Markup Summary

EGP-19-003

SITE MAP  
N.T.S.

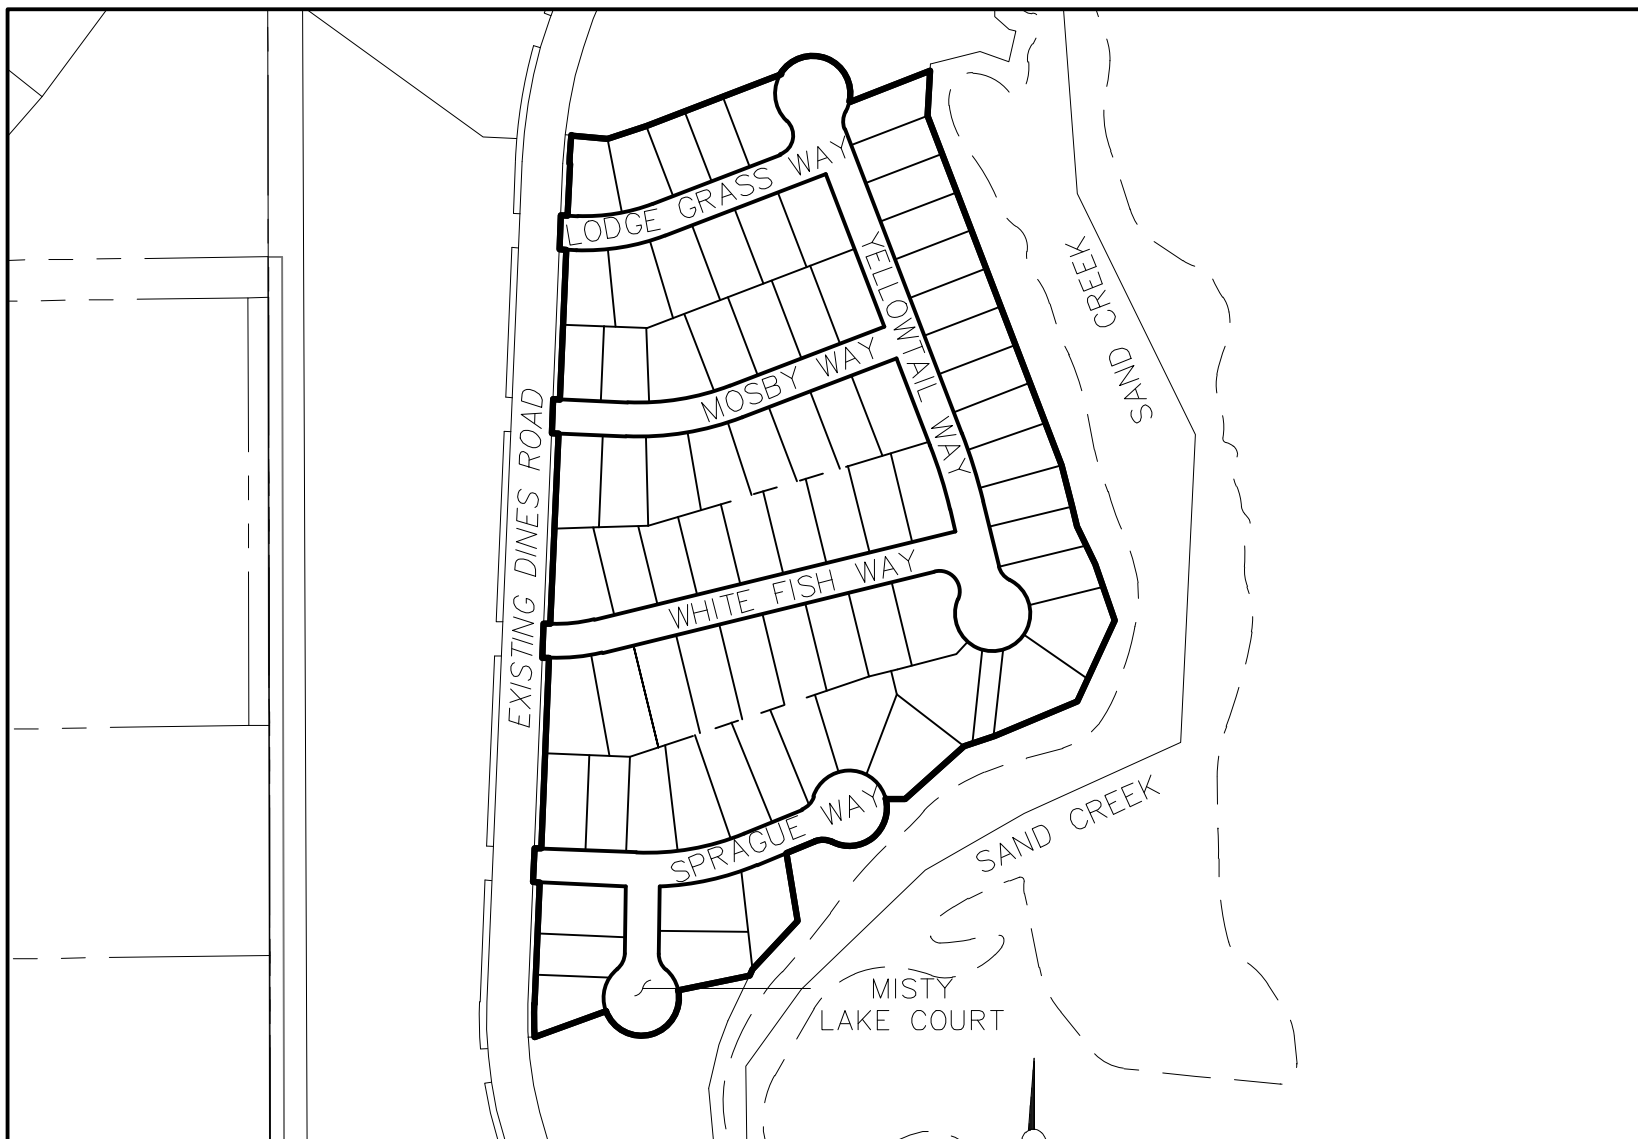
Add: The Sterling Ranch Metropolitan District is responsible for ownership and maintenance of the under-drain system shown on these plans.

LOT DRAINAGE TYPES AND  
SWALE DIRECTION  
NOT TO SCALE

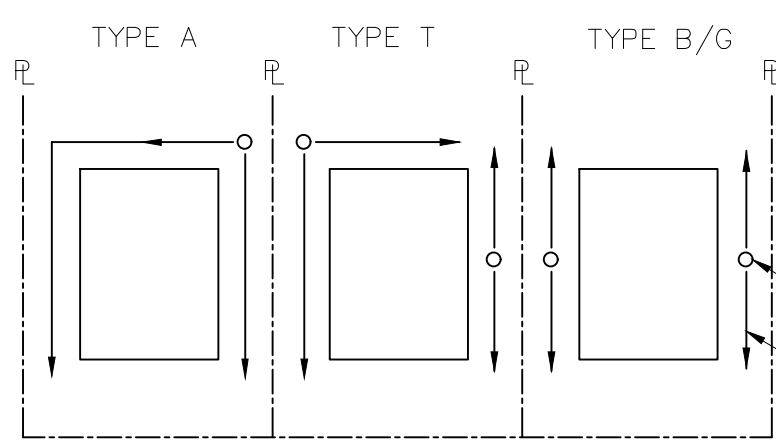
The features that are shown on this plan that are closer than 50 feet to the top of slope need to be removed. El Paso County PCD Engineering cannot approve a plan for this area until we have accepted the drainage report (See SF-19-004 comments). Additionally, this 50 foot is called out in the CDPHE construction permit COR400000, that all contractors performing drainage have to comply with. So this EGP needs to show this area as not to be entered.
